CITY OF ALBUQUERQUE

**RE: 8008 Compass Dr. NW
Grading and Drainage Plan
Engineers Stamp Date 11/29/14 (D10-D003K9)**

Based upon the information provided in your submittal received 12/1/2014, the above referenced Grading and Drainage Plan cannot be approved for Grading Permit or Building Permit until the following comments are addressed.

LOT 9, BLOCK 5, UNIT 18 VCS
8008 COMPASS DRIVE, NW
GRADING PLAN

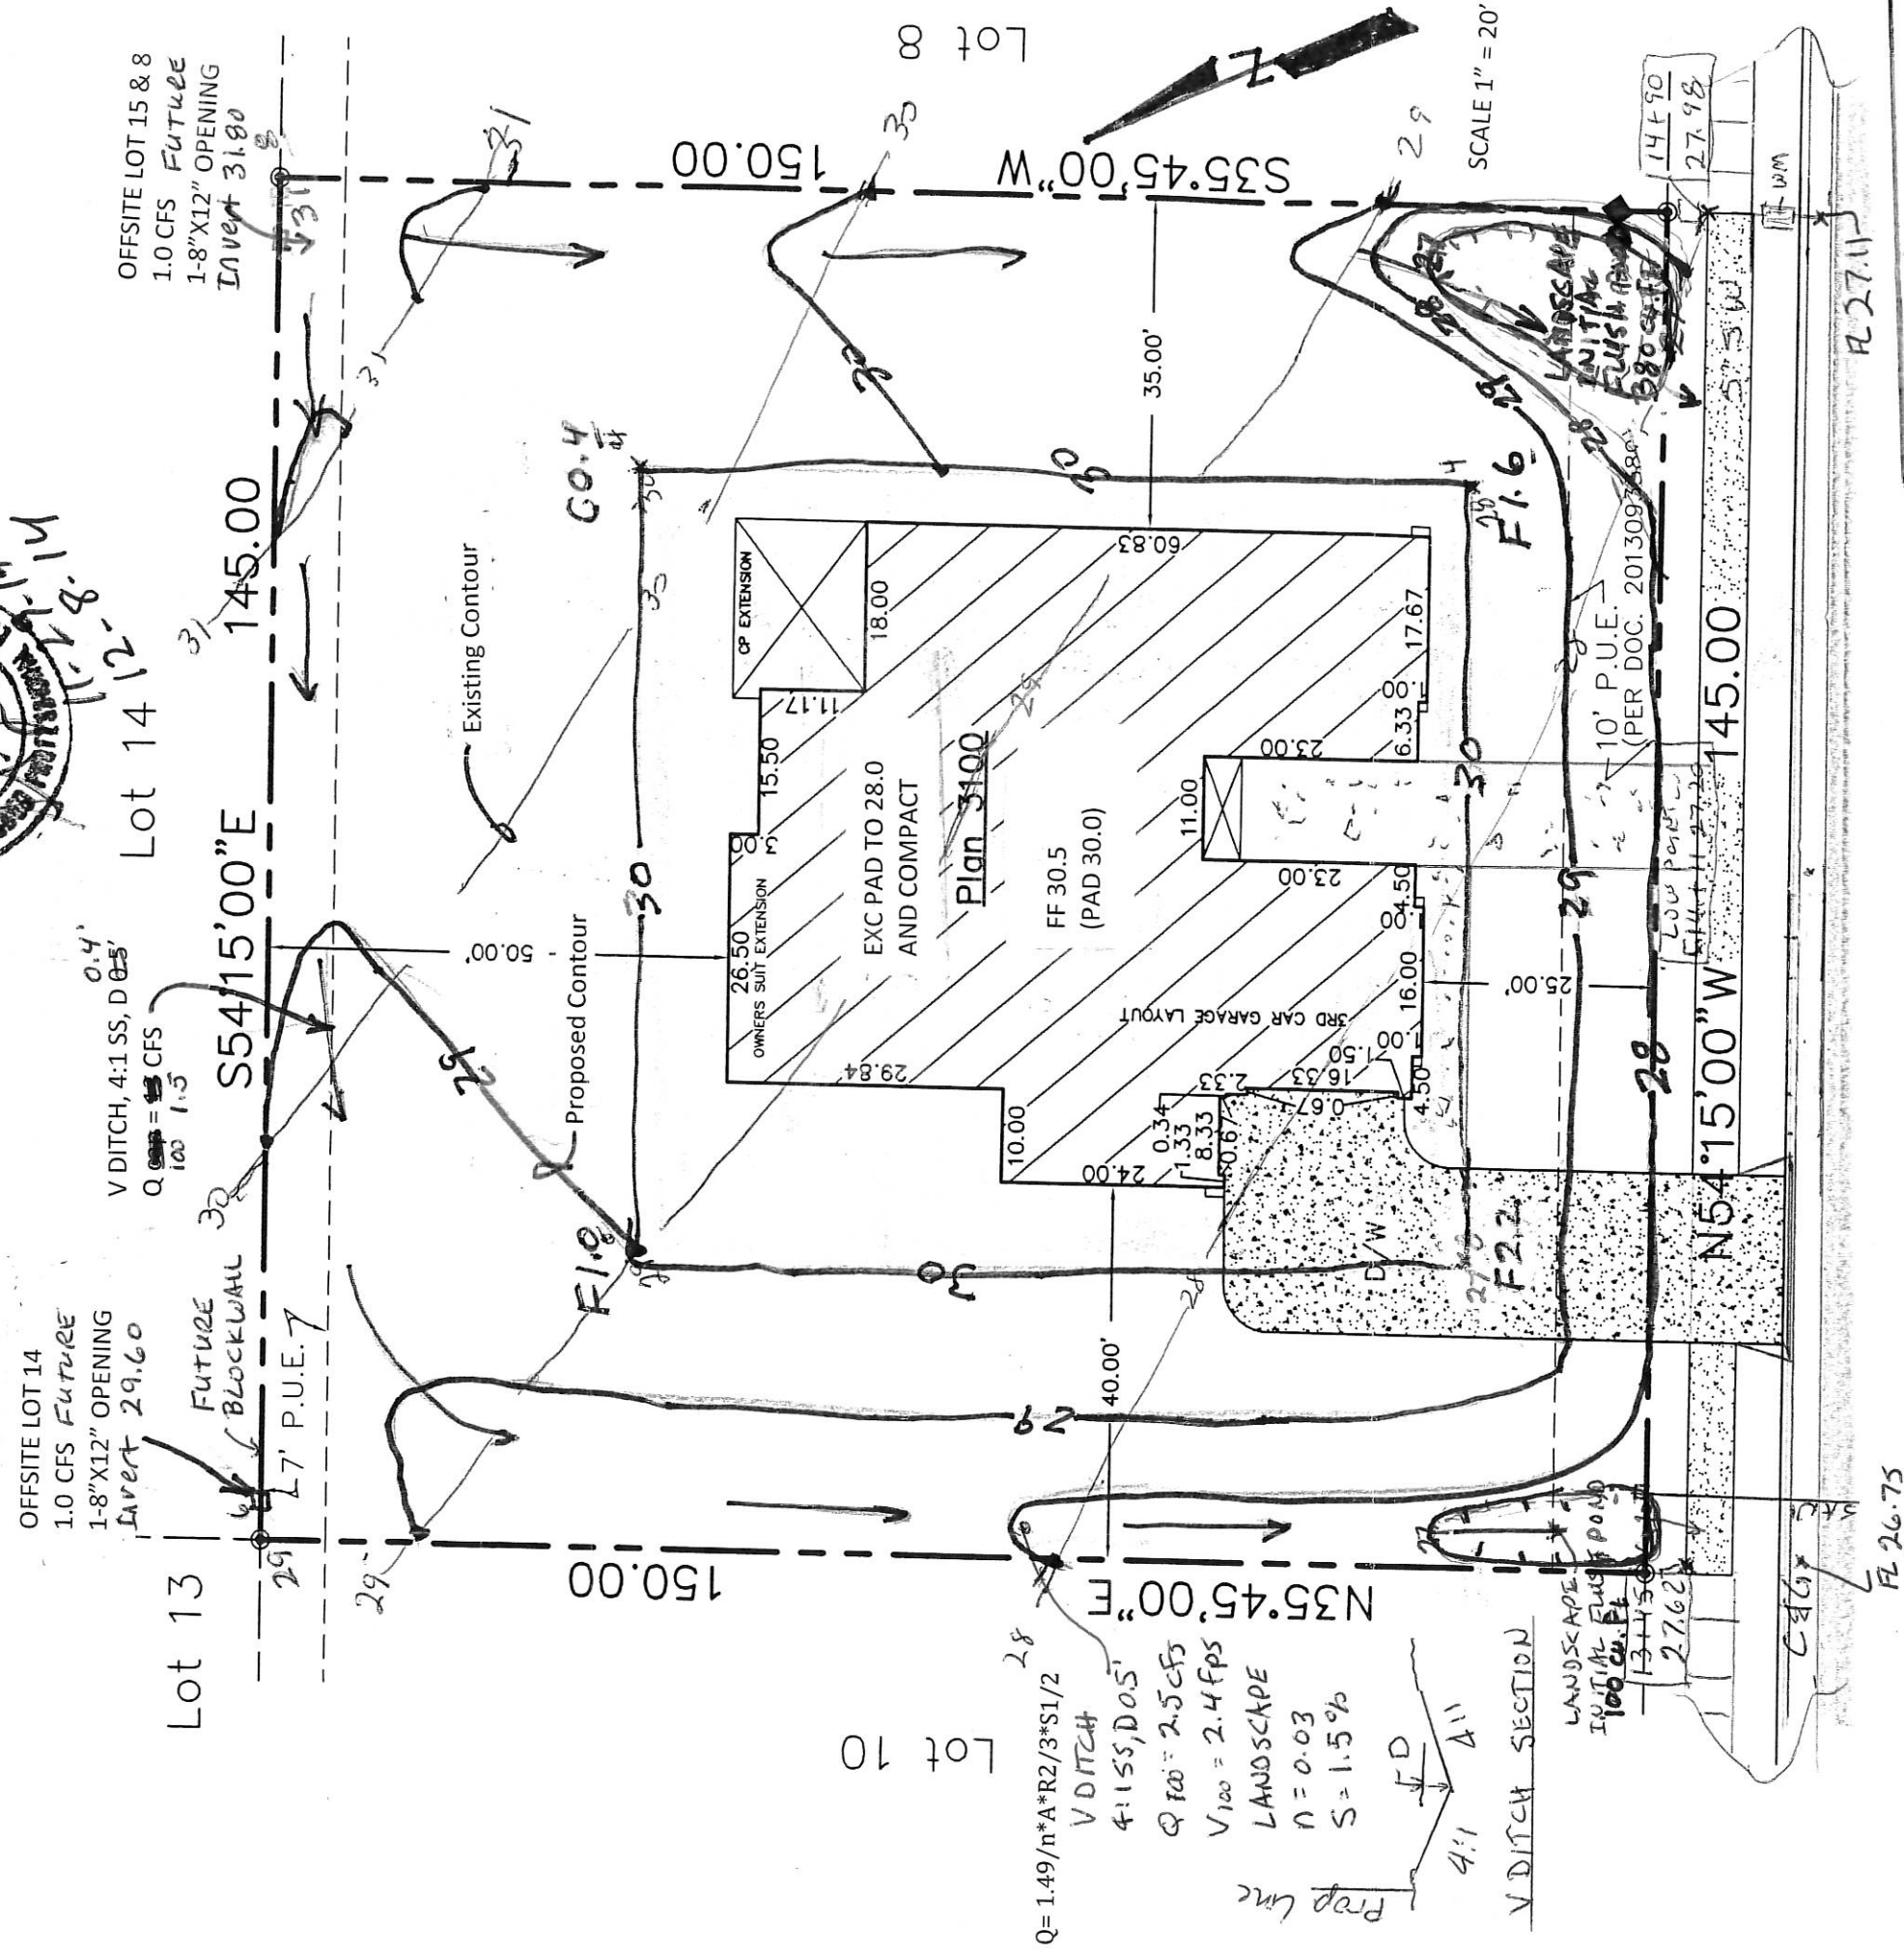
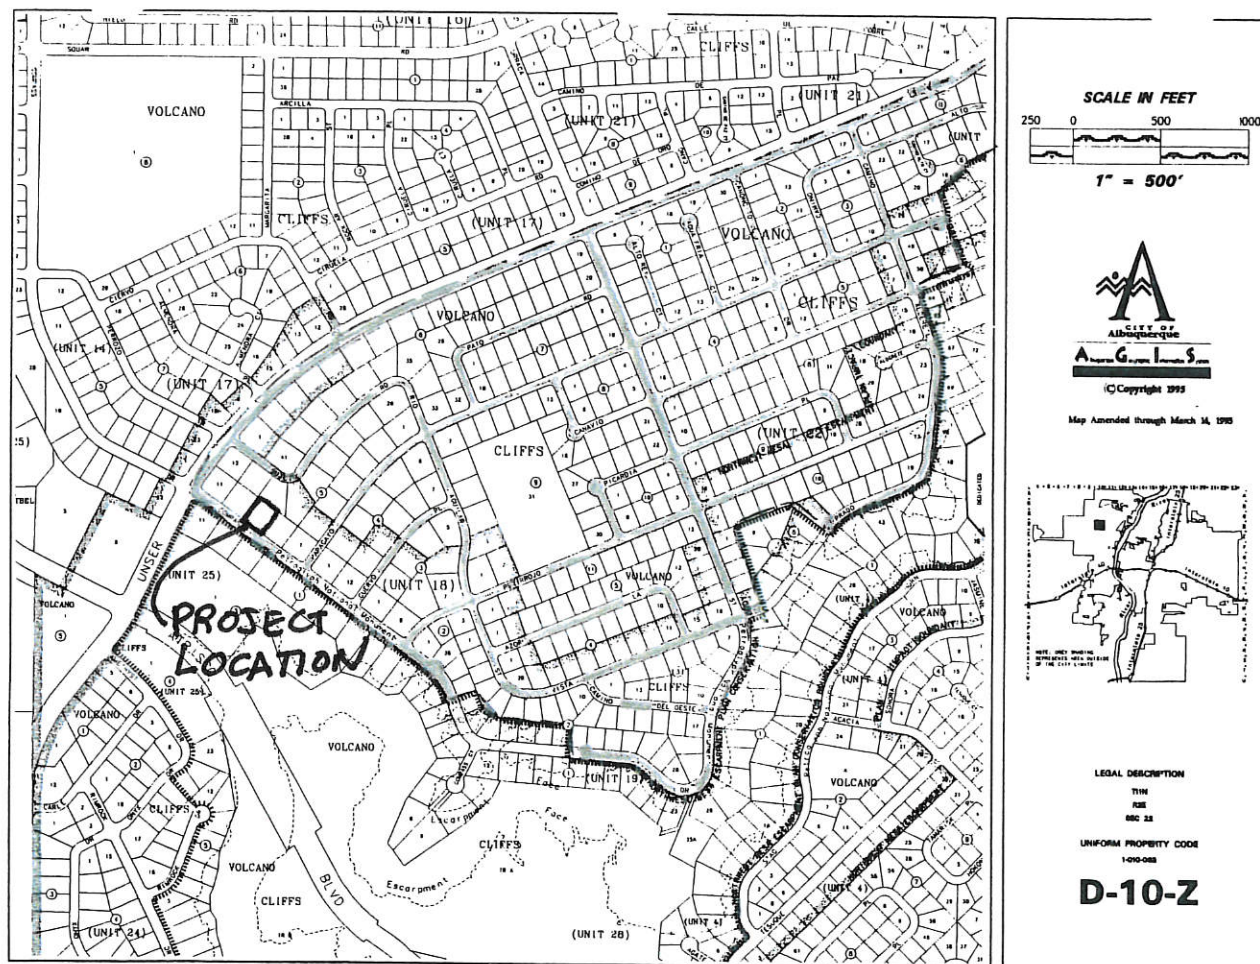
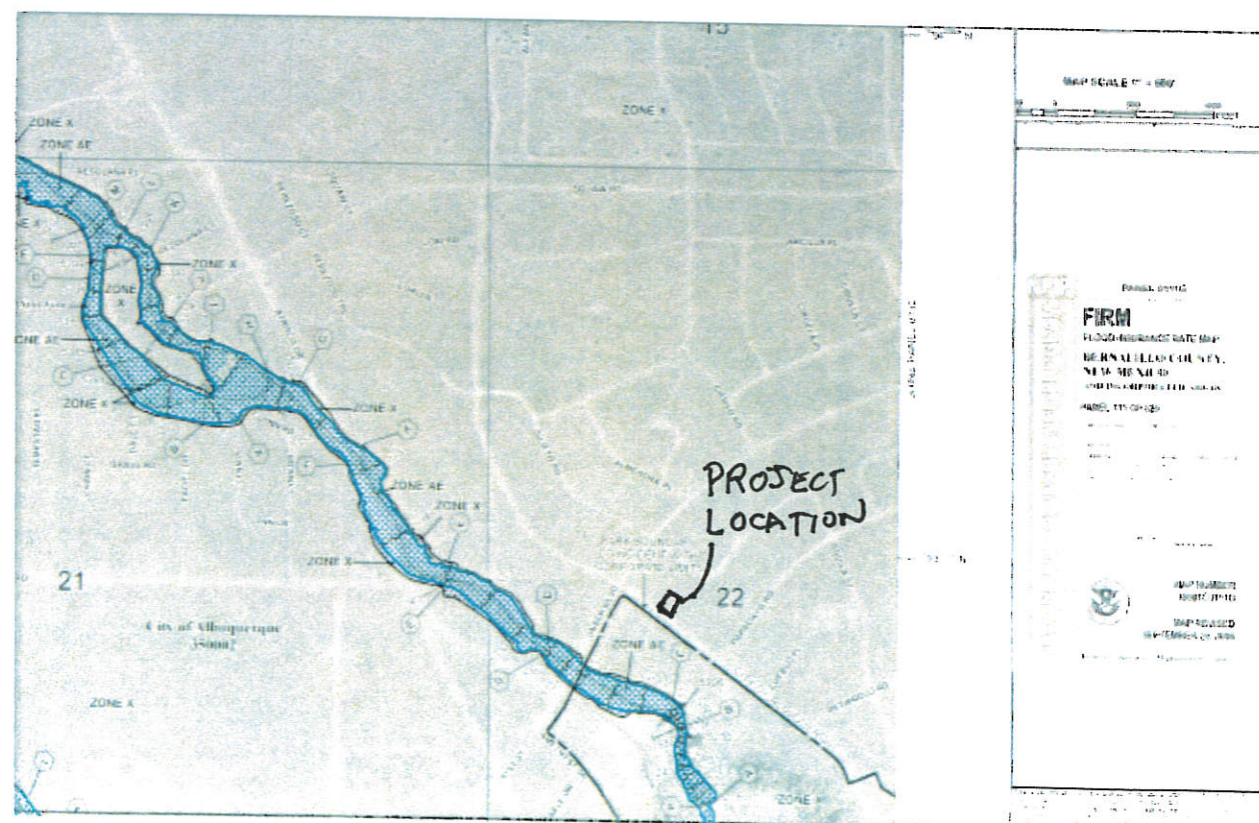
- Provide a Vicinity map, a FEMA map or designation, a narrative.
- Mention of the first flush per EPA standards is required. The amount required is .34" times the impervious area.
- Provide a section of the V Ditch and calculations for the ditch. 13.0cfs seems a bit too much. Is the ditch a shared ditch, if so where will the block fence be placed?
- What are the inverts of the openings? Is this a block fence?
- What is the flow line in the street?
